Subject: Rezoning Petition Review

Rezoning Petition #: 22-029

Location of Property: Approximately 0.95 acres located at the northwest intersection of Seigle Ave and Van Every St, west of Belmont Ave.

Skyline Townes
Rezoning Site Plan
 955 Seigle Avenue Charlotte, North Carolina

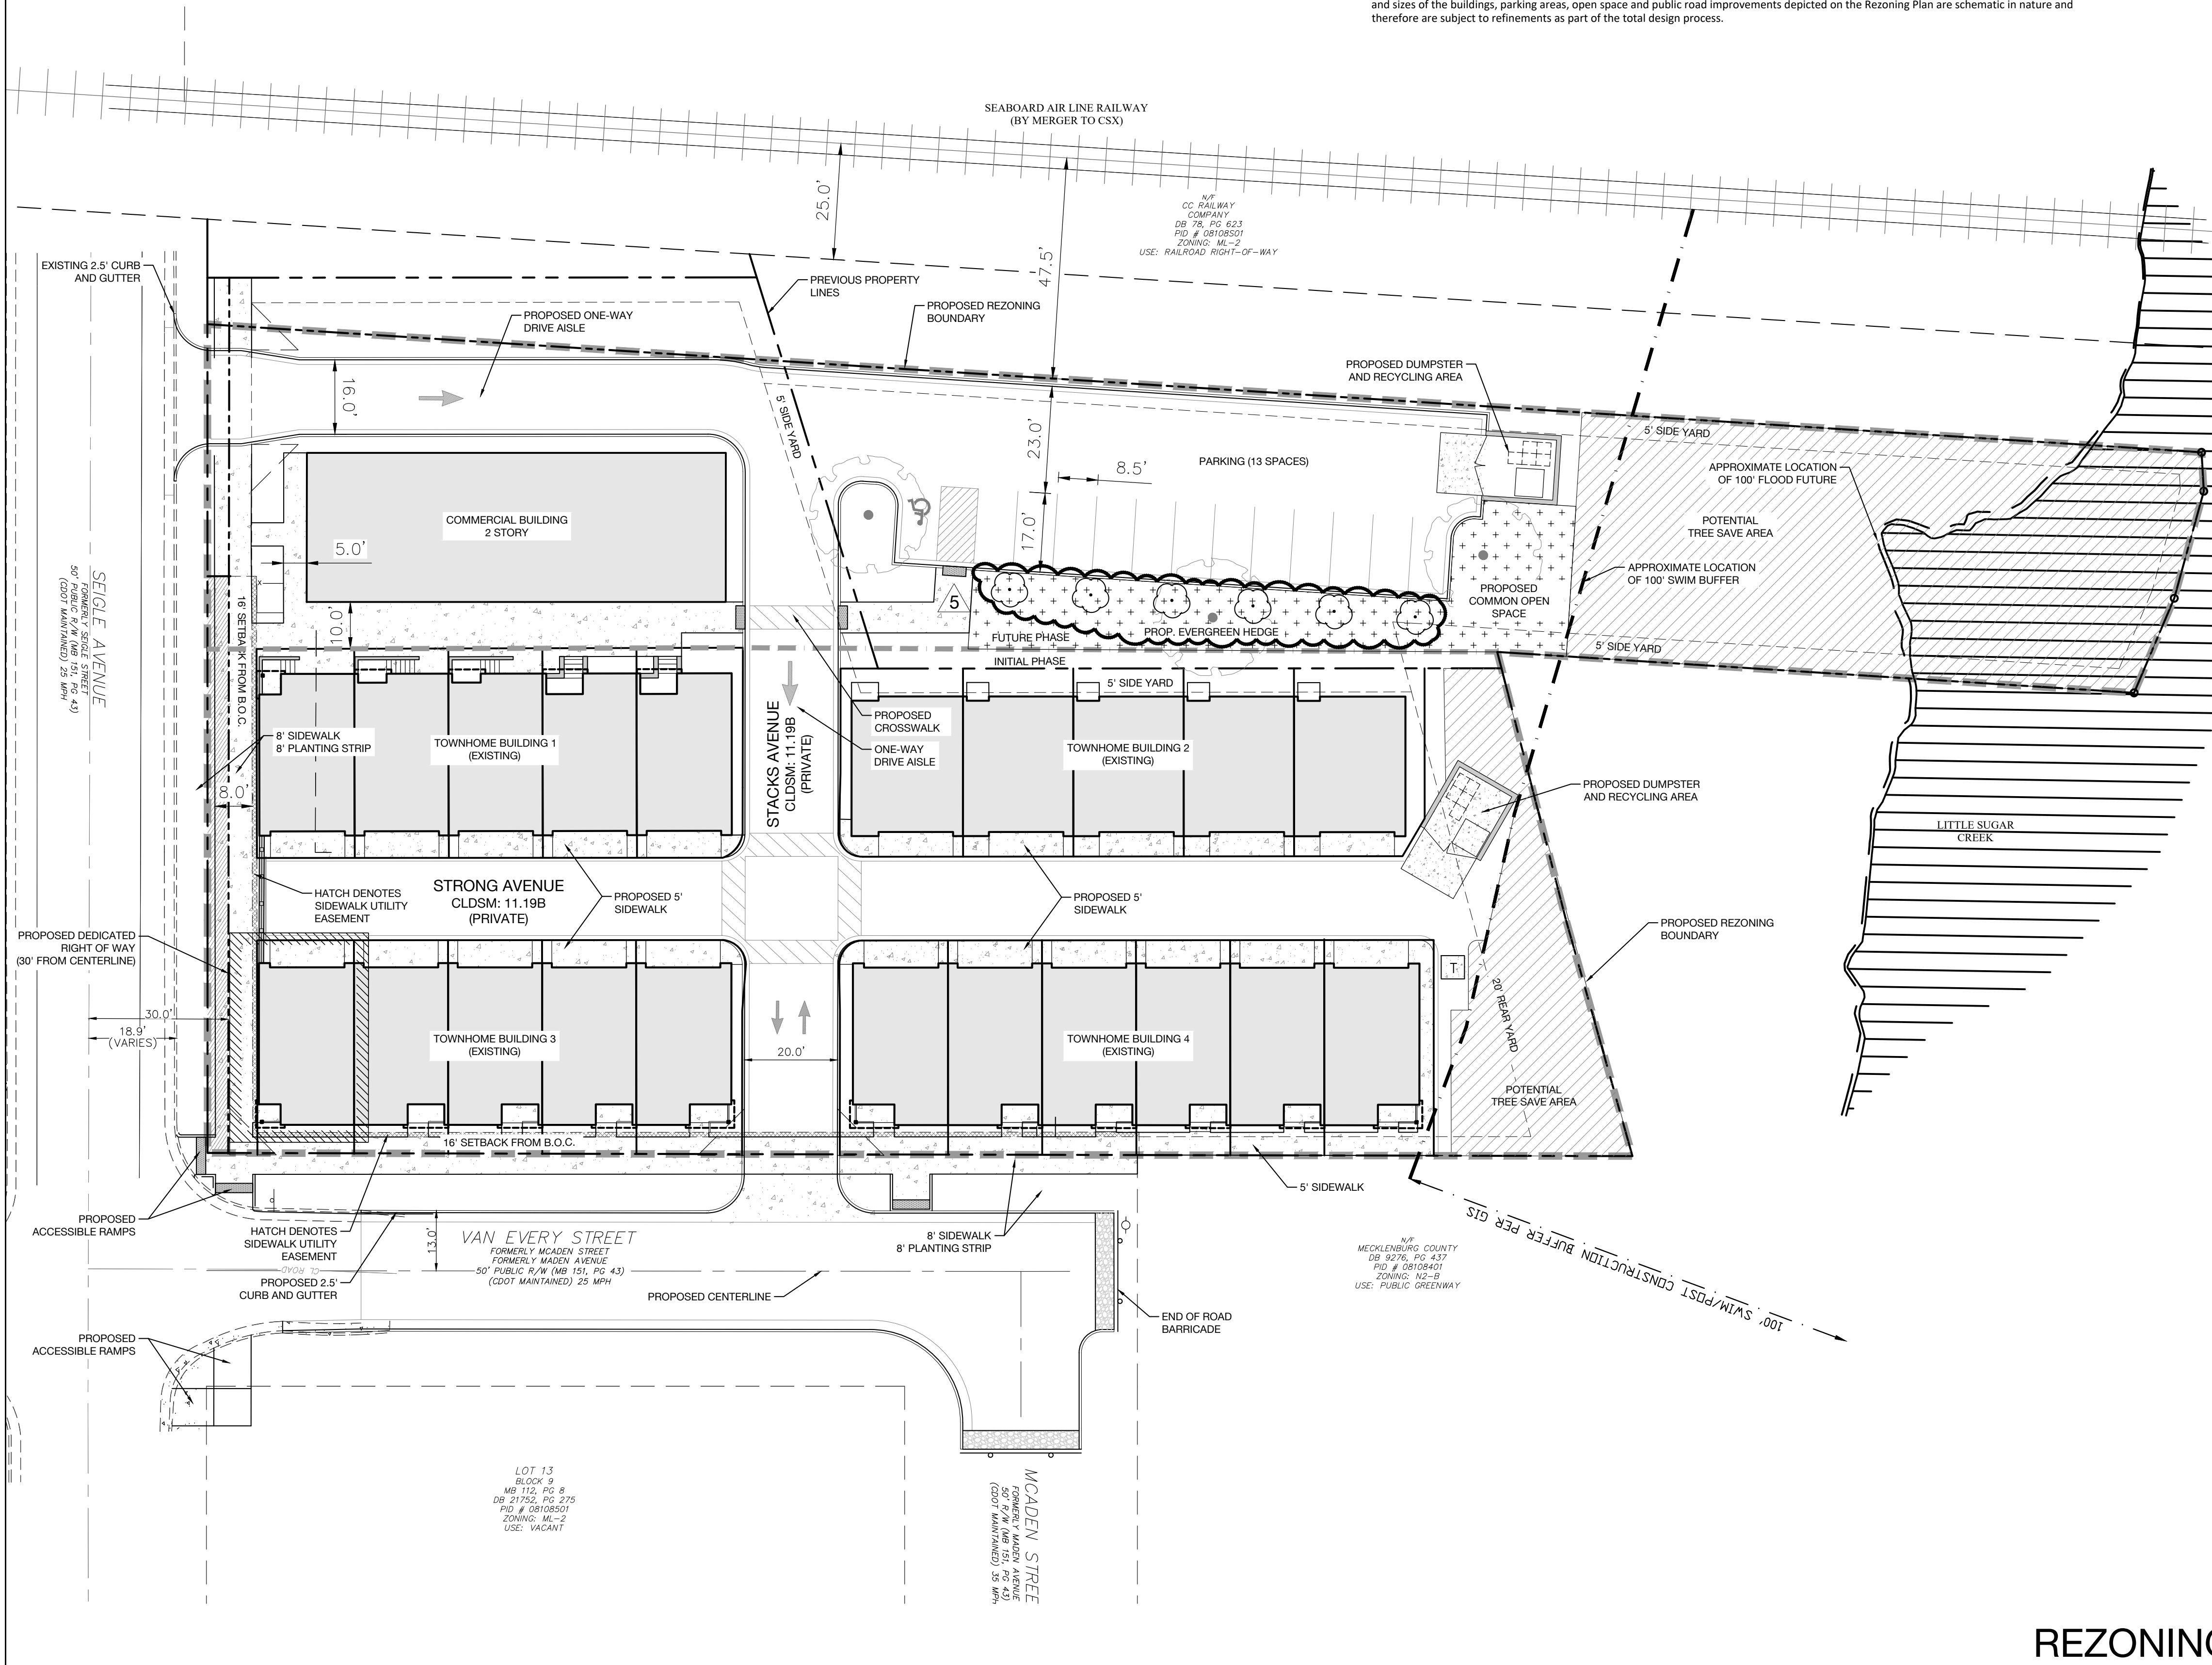
This property drains to Upper Little Sugar Creek, which is an impaired/degraded stream, and may contribute to downstream flooding. This project has the opportunity to mitigate future impacts to this stream, therefore, Storm Water recommends placing the following notes on the plan:

For defined watersheds greater than 24% built-upon area (BUA), construct water quality stormwater control measures (SCMs) designed for the runoff generated from the first 1-inch of rainfall for all new and redeveloped BUA associated with the project. SCMs must be designed and constructed in accordance with the Charlotte-Mecklenburg BMP Design Manual.

For defined watersheds greater than 24% built-upon area, control the entire volume for the 1-year, 24-hour storm for all new and redeveloped BUA associated with the project. Runoff volume drawdown time shall be in accordance with the Charlotte-Mecklenburg BMP Design Manual.

For commercial projects with greater than 24% BUA, control the peak to not exceed the predevelopment runoff rates for the 10-yr, 6-hr storm and perform a downstream flood analysis to determine whether additional peak control is needed and if so, for what level of storm frequency, or if a downstream analysis is not performed, control the peak for the 10-yr and 25-yr, 6-hour storms.

For residential projects with greater than 24% BUA, control the peak to not exceed the predevelopment runoff rates for the 10-year and 25-year, 6-hour storms or perform a downstream analysis to determine whether peak control is needed, and if so, for what level of storm frequency.
